Application No: BE/18/26/PL
Site Address: Land West of 26 Greystone Avenue Bersted PO21 5EA
Description of works: Erection of 1 No. detached four-bedroom dwelling (self build) with associated car parking, bike store and landscaping. This application is in CIL Zone 4 and is CIL Liable as a new dwelling.

Thank you for your internet representation made on 11th April 2026 which has been recorded as an objection with the comments as follows:

A :: Propopsed South East Elevation
01 scale: 1:100

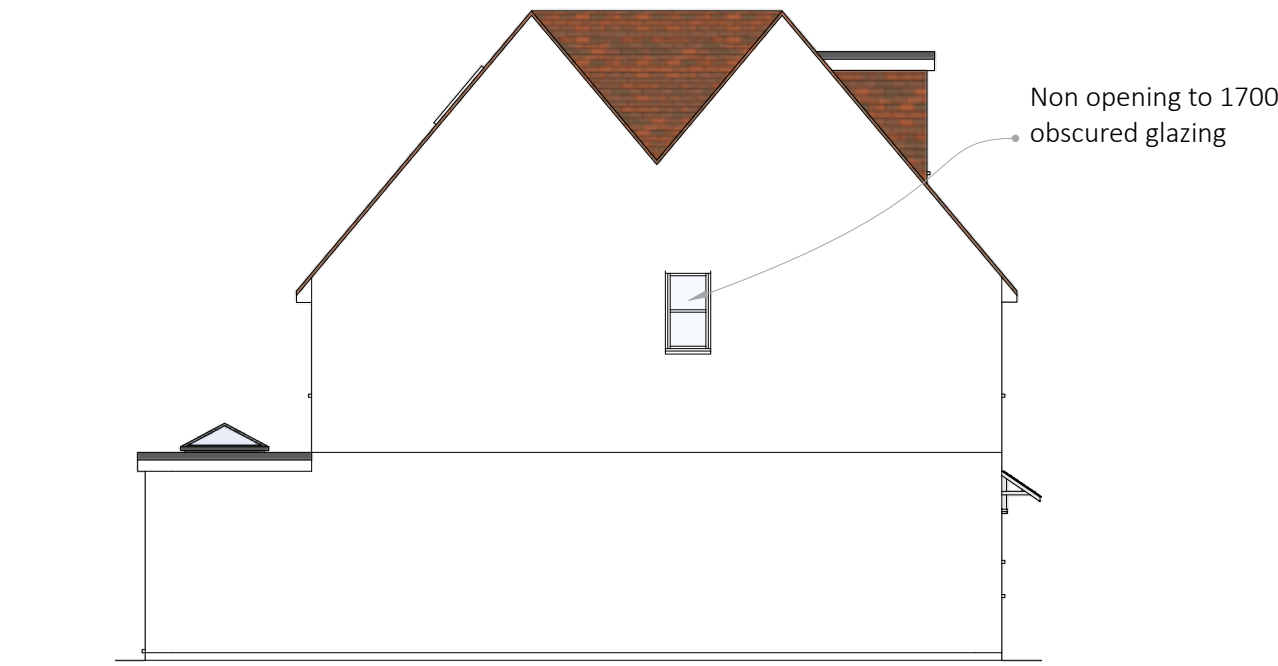
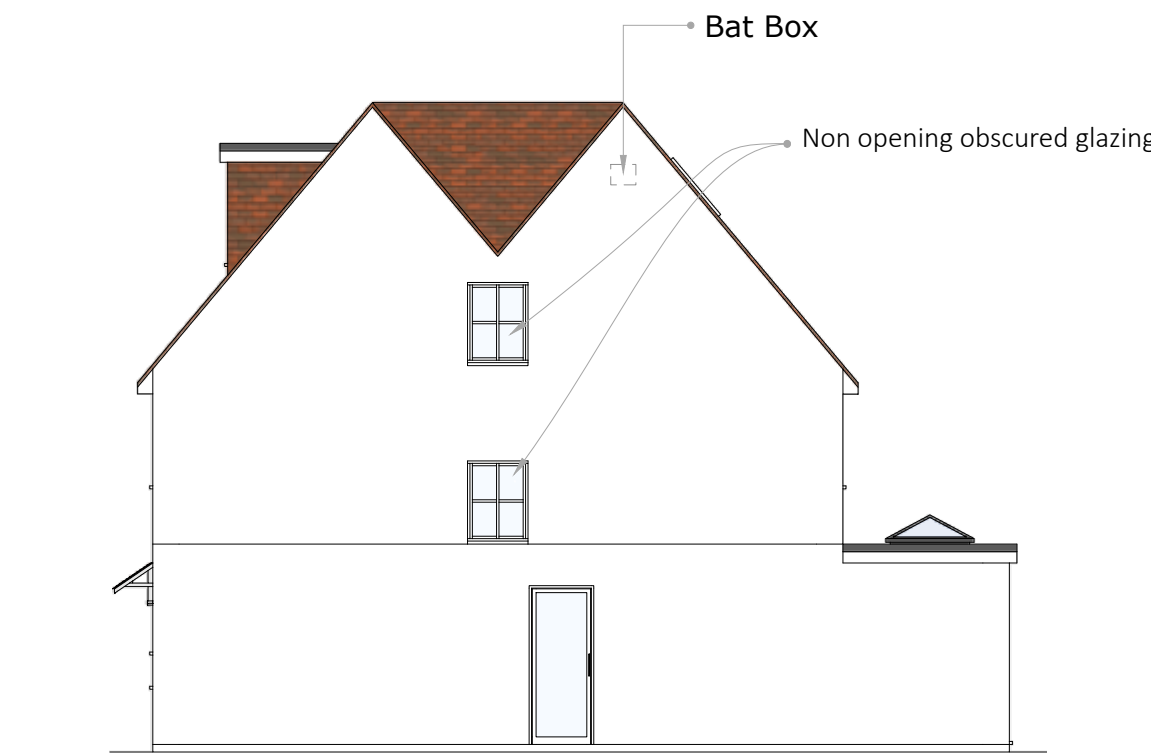
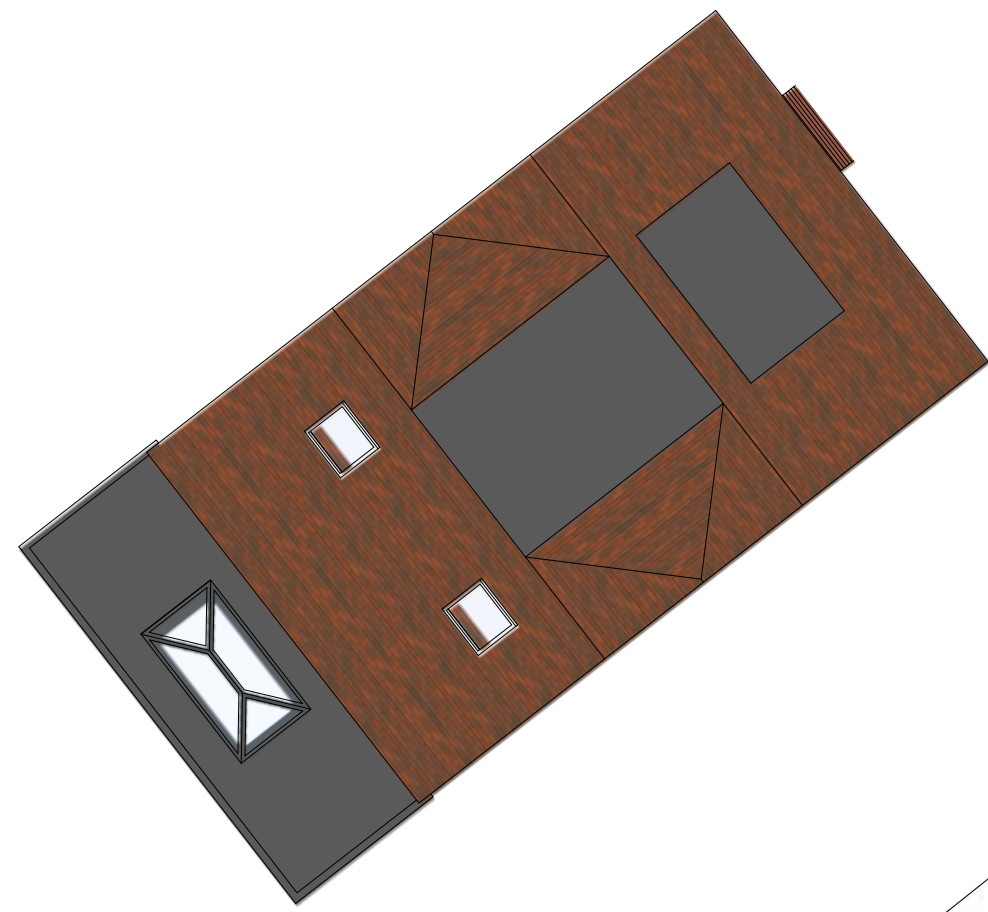
I am writing to register my views concerning the proposed building of a 4 bedroom house on this very narrow strip of land at the end of Greystone Avenue cul-de-sac. It will overlook a bungalow, no. 26, and be in close proximity to two bungalows in Loats Lane. The dormer windows shown on plans will make the two-storey development appear to be a three-storey house. It will dominate and overlook the properties and gardens on the north side of Greystone Avenue. It is overdevelopment and will have a detrimental impact on the neighbourhood including our privacy.
